From: Claire Potts
Sent: 26 March 2019 11:52
To: Lynnyrd Wolfe
Subject: FW: BE/135/18/PL - Salt Box - Amended Drawings
Attachments: Schedule of Sumbitted Drawings v4 180319.pdf; 1744-UF-P04-C.pdf; 18020 4001-PL-B_PropElevs.pdf

From: Nia Russell [REDACTED]
Sent: 18 March 2019 12:43
To: Michael Eastham
Cc: Claire Potts; Arfon Hughes
Subject: Re: BE/135/18/PL - Salt Box - Amended Drawings

ESTD	SBX - BSL - ZZ - XX - DR - A -	4001 - PL								
	Project	Originator	Volume	Level	Type	Role	Series	Number	Suitability	Revision

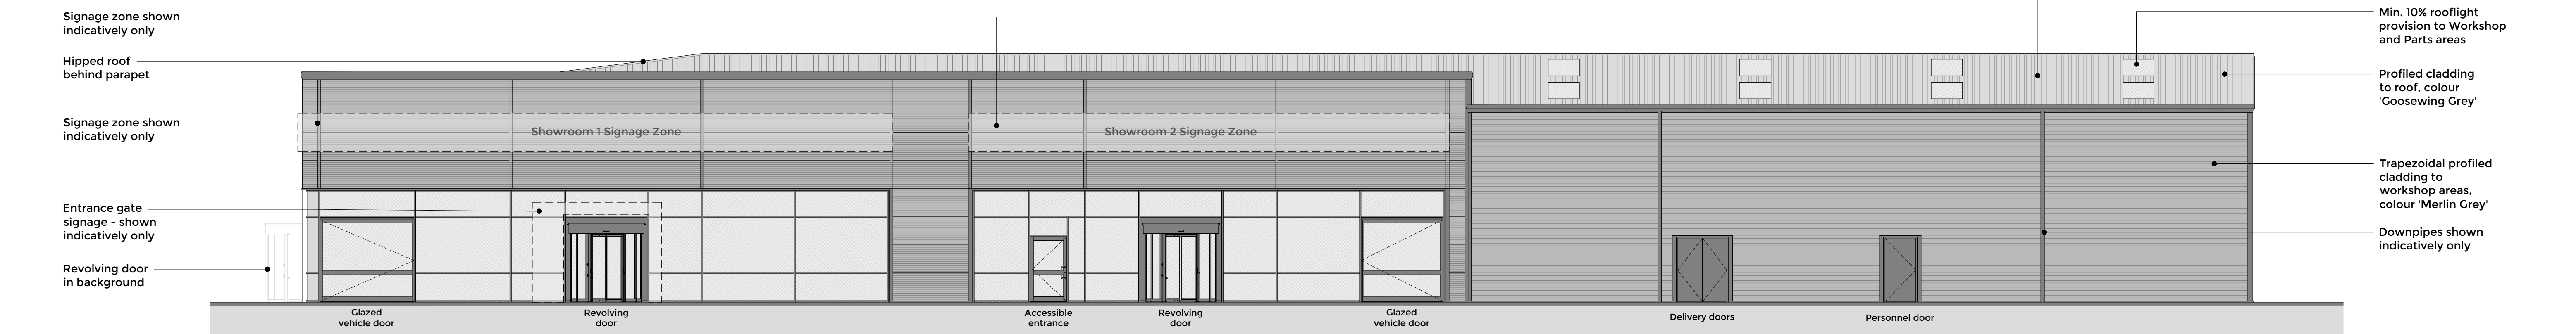
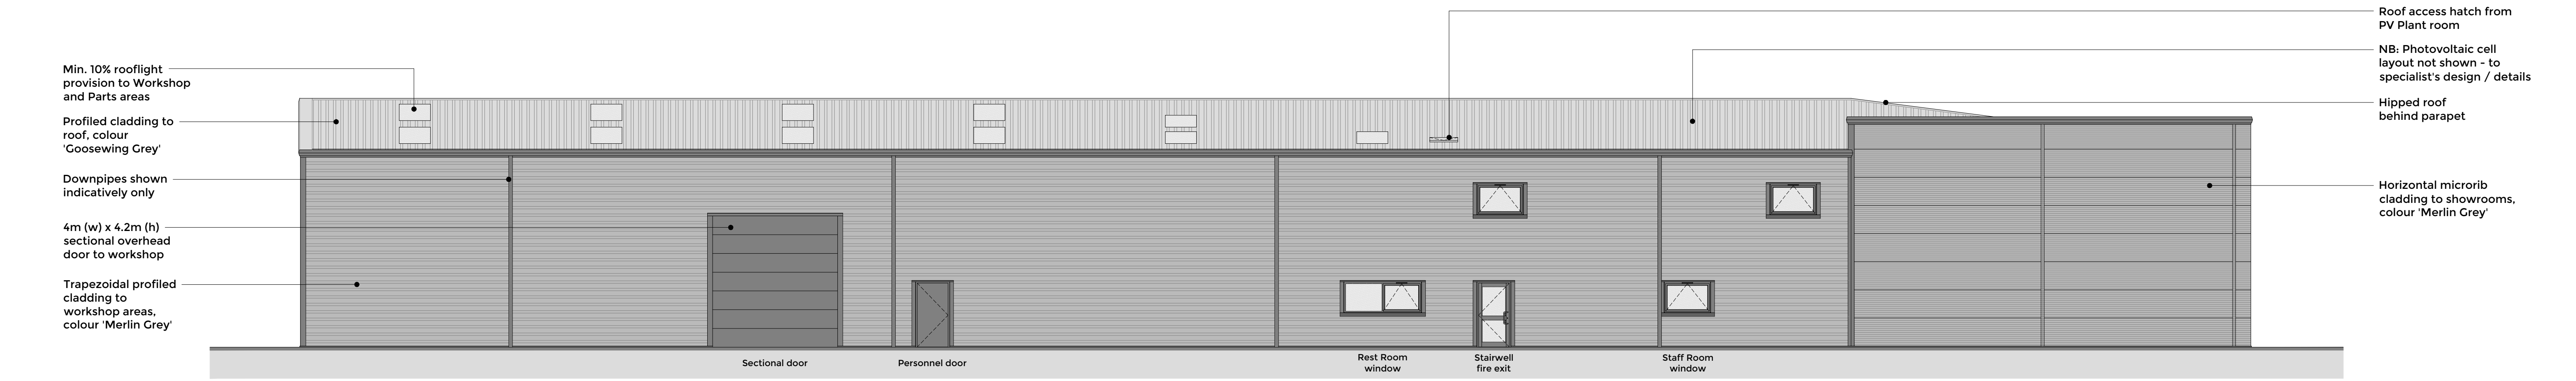
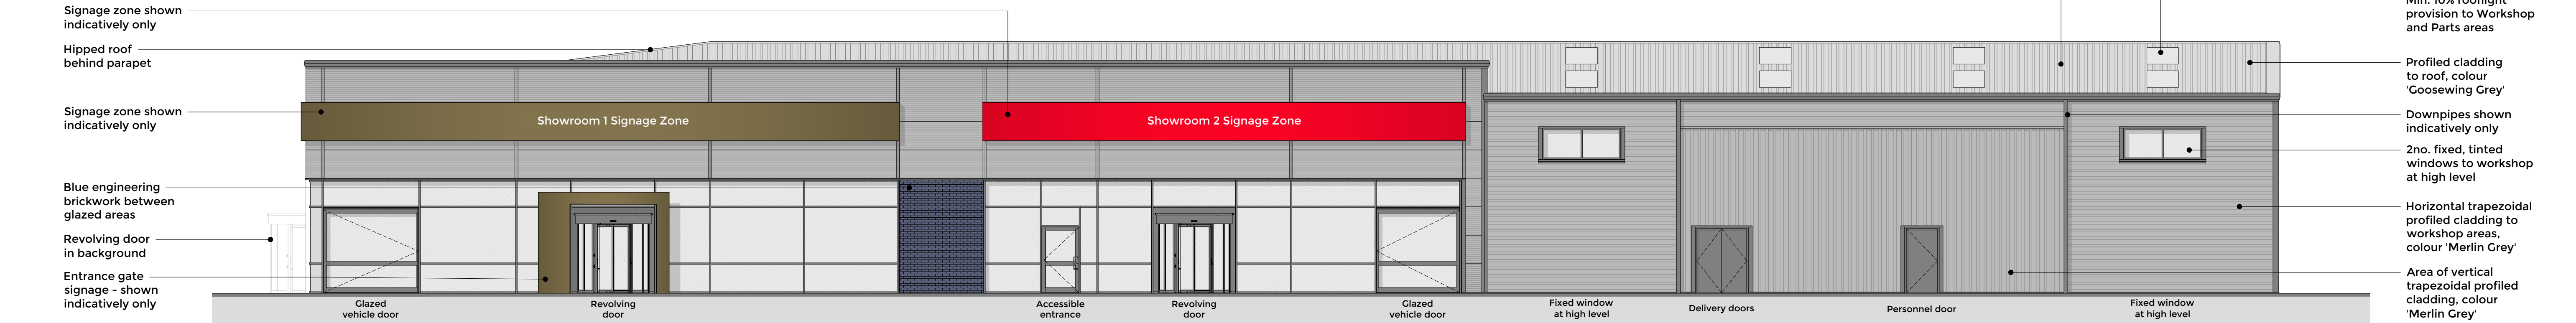
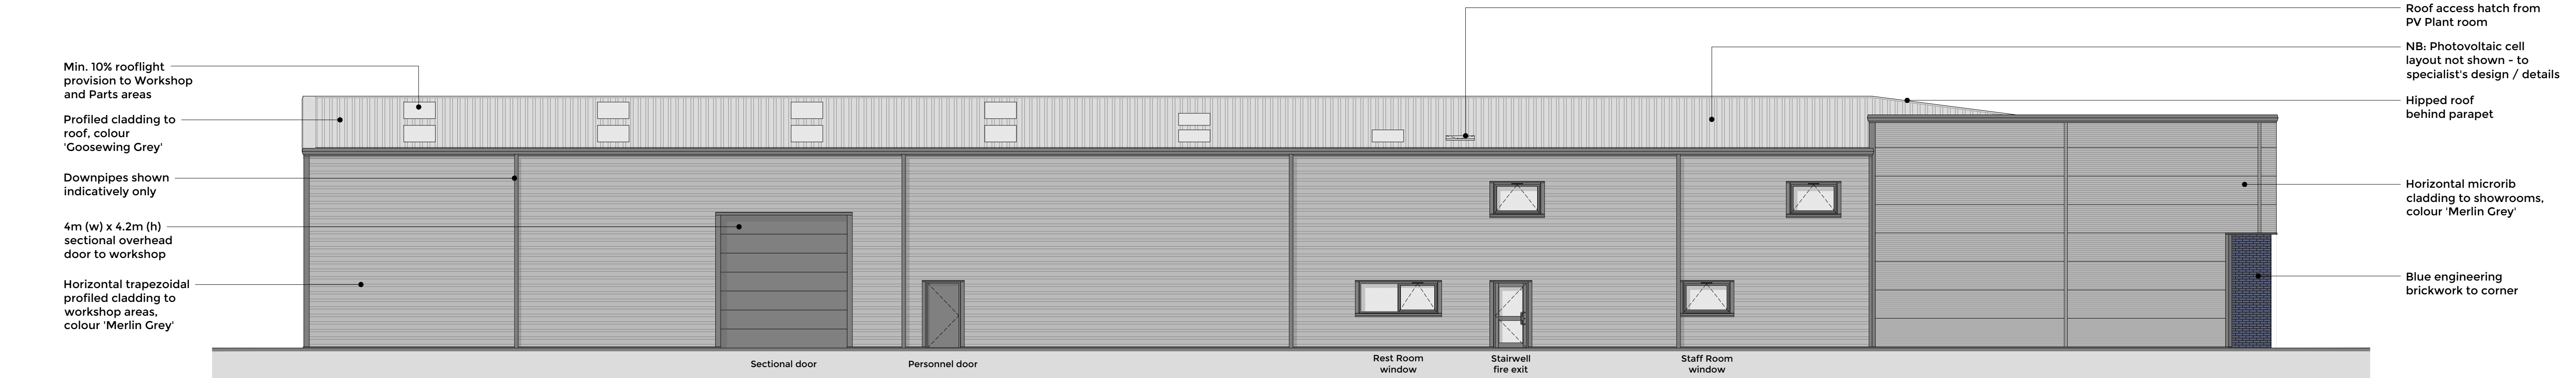
The blue feature bricks work well on the northern elevation of the Car showroom building. Could the car showroom have blue bricks from the ground to the eaves of the roof on the south east and north east corners of the building facing onto Shripney Road? Could the northern elevation of the car workshop include a strip of vertical cladding in dark grey, to mirror Units 6 and 7, to break up the visual mass of the building?

With regard to the Car Sales showroom, we have added blue engineering brickwork to the south-east corner as suggested, but not to the north-east, as this would mean losing the feature glazed corner of the main car showroom. Our architects feel that taking these brickwork zones all the way up to eaves level would create

a degree of separation between dealerships (whereas the cladding currently links them all together), and would also be likely to create complicated weatherproofing details at parapet level, so we have kept the brickwork to the same height as the curtain walling. We have also introduced a zone of vertical trapezoidal cladding, among the horizontal currently proposed, to the north elevation of the workshop to assist in breaking up the elevation.

A revised Drawing 4001 -PL- B is attached showing these alterations.
